Please see the response form our consultant regarding condition 16.

Figure 3 – Trial Hole Plan

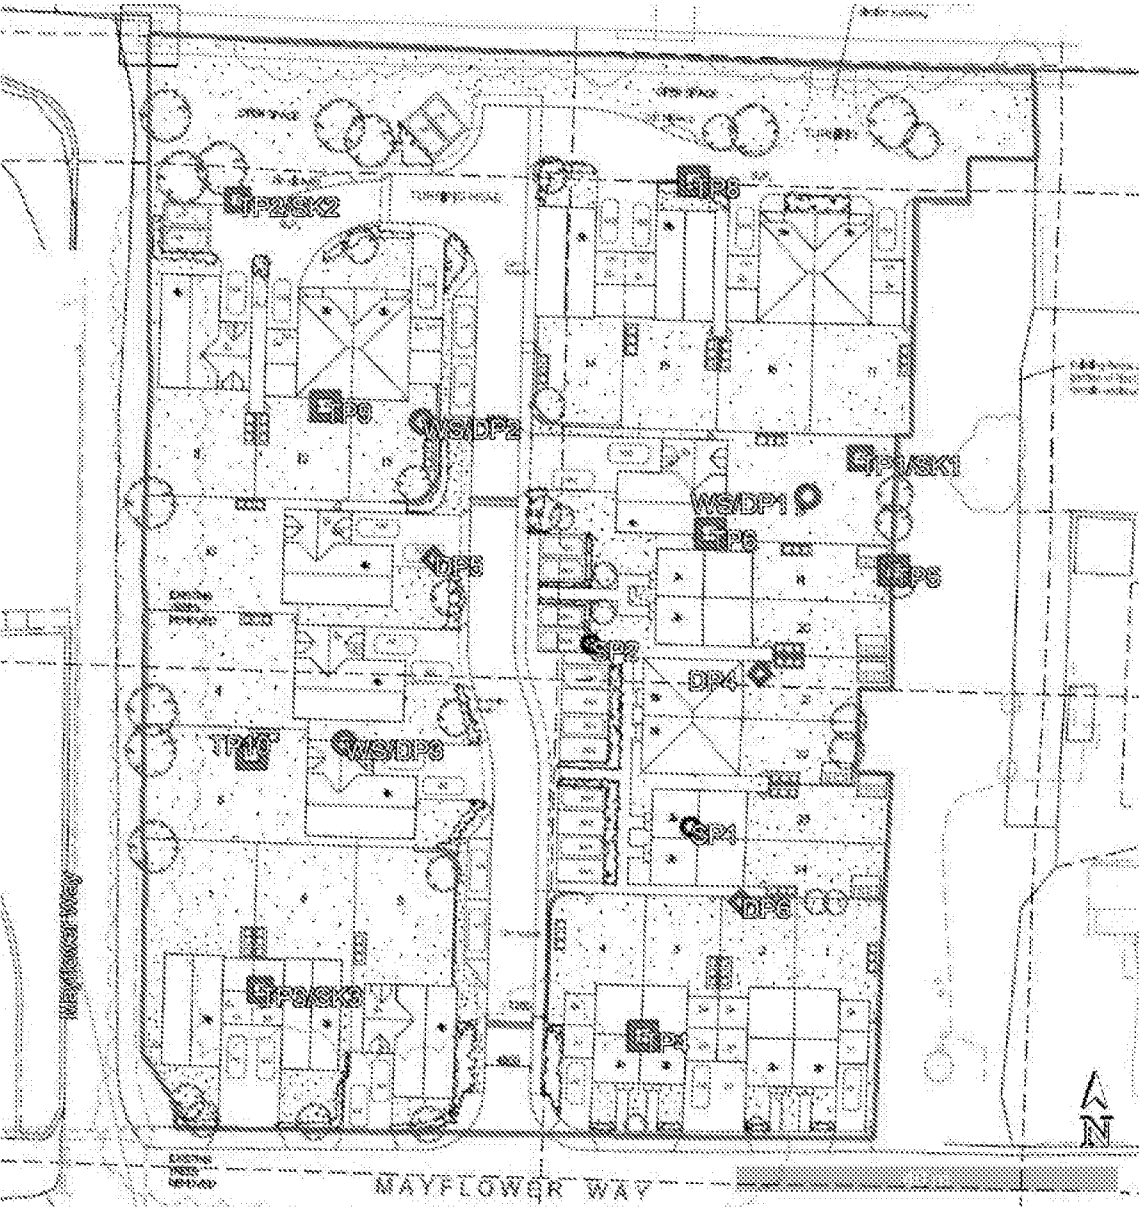
It is understood that the trial pit where the elevated concentration of lead was identified has been excavated and covered by hardstanding. It is of concern, however, that no further testing was undertaken in the garden areas of the plots in question. Excavation and imported certified clean material is a valid method of remediation, however we would expect to see a minimum of 600mm removed and replaced or a depth of 300mm removed and placed but with the addition of a geotextile membrane. If the applicant can confirm that either of these options have been met, this will be considered satisfactory. If not, it is recommended that further sampling is undertaken in the garden areas/areas of soft landscaping of the plots in question. The sampling strategy may include any areas of soft landscaping to the front of the plots in question. A suitably qualified, independent consultant should be engaged to further advise on the required sampling regime.

- 1) *the CGIR identified an exceedance of lead at 0.10 metres depth and stated that based on the proposed development plan, no remediation was required, however no management of this exceedance is mentioned and no subsequent sampling of the garden areas was undertaken;*

The area where the elevated lead concentration was encountered was beneath the proposed buildings of plot 6 & 7 and at shallow depth. The attached drawings show that site levels were to be reduced in this area by between 200 and 300mm and therefore the encountered lead would have been removed during construction and, even if present at greater depth, would have been covered so that it would not present a risk to the end-user. With regards to the garden areas of plots 6/7, it is acknowledged that no supplementary sampling testing has been undertaken, however, given the proposed site level changes across these garden areas along with the need to replace the surface soils with an appropriate growing medium / topsoil then the same would apply to these areas i.e. removal of material to facilitate level change and further replacement of near surface soil with imported clean material.

Gas protection to level **CS2**.

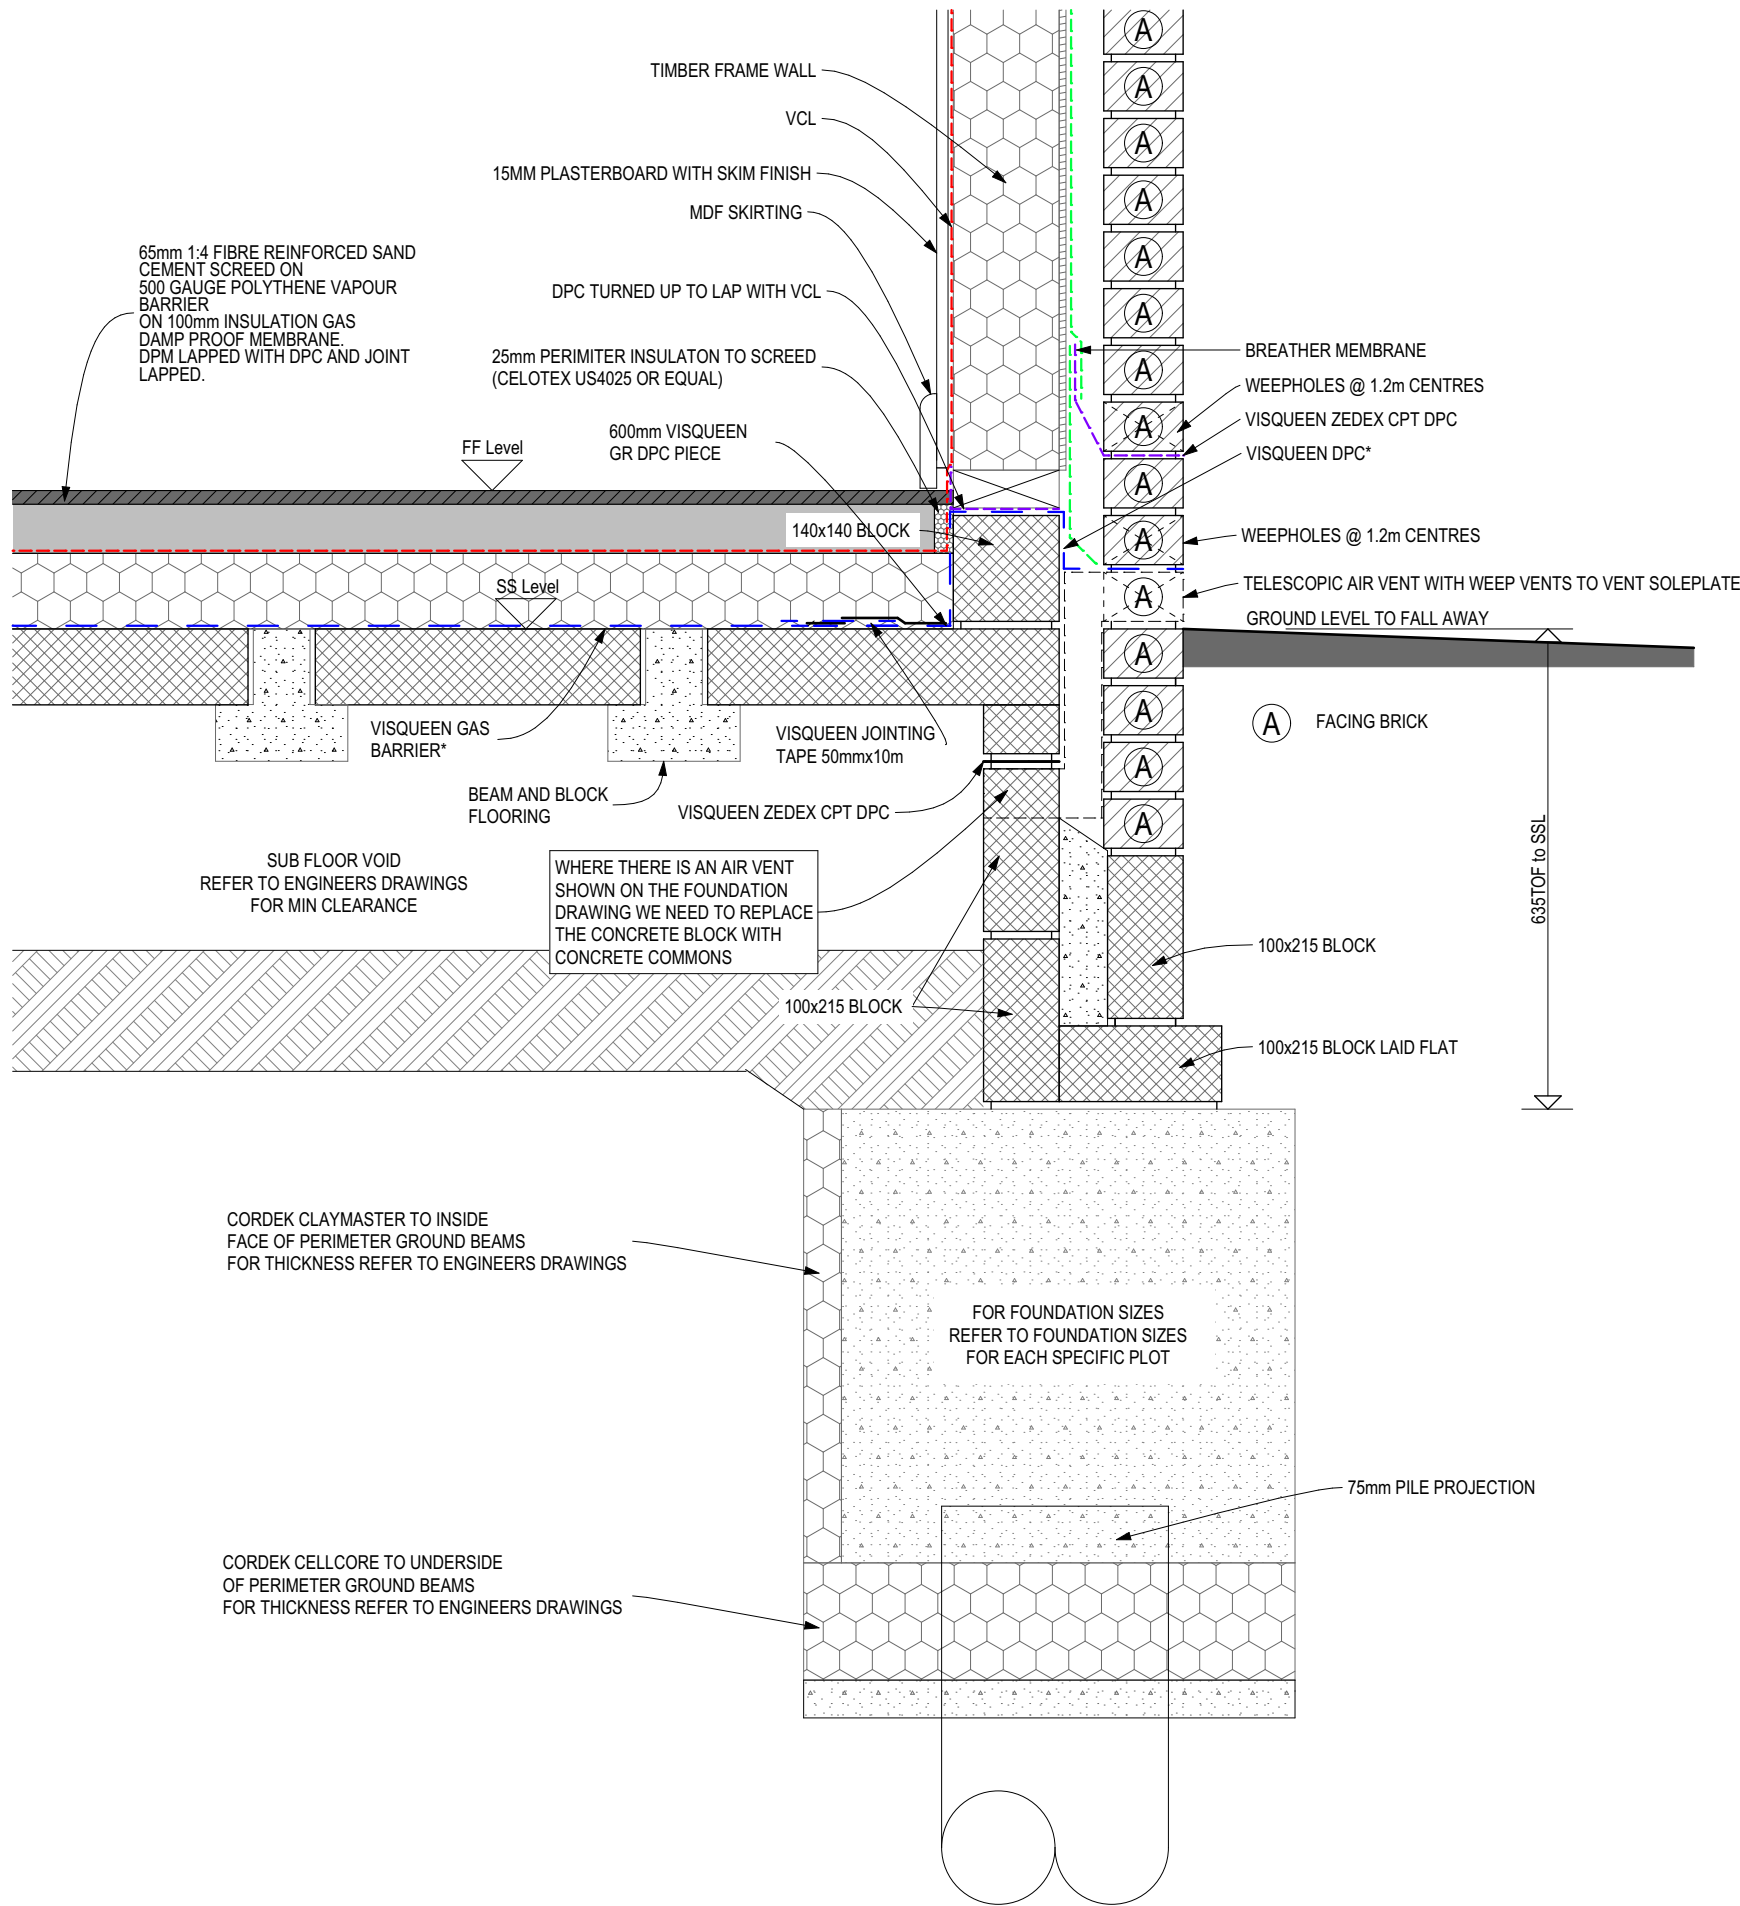
- 2) *the SGRA concludes that gas protection measures are likely to be required, however no detail is provided.*

- the CGIR identified an exceedance of lead at 0.10 metres depth and stated that based on the proposed development plan, no remediation was required, however no management of this exceedance is mentioned and no subsequent sampling of the garden areas was undertaken;
- the SGRA concludes that gas protection measures are likely to be required, however no detail is provided.

I have attached our standard gas membrane detail for these situations as requested in their email.

The Local Authority should be provided with the appropriate cross section drawings relating to the gas membrane installation along with details of the intended membrane to satisfy CS-2.
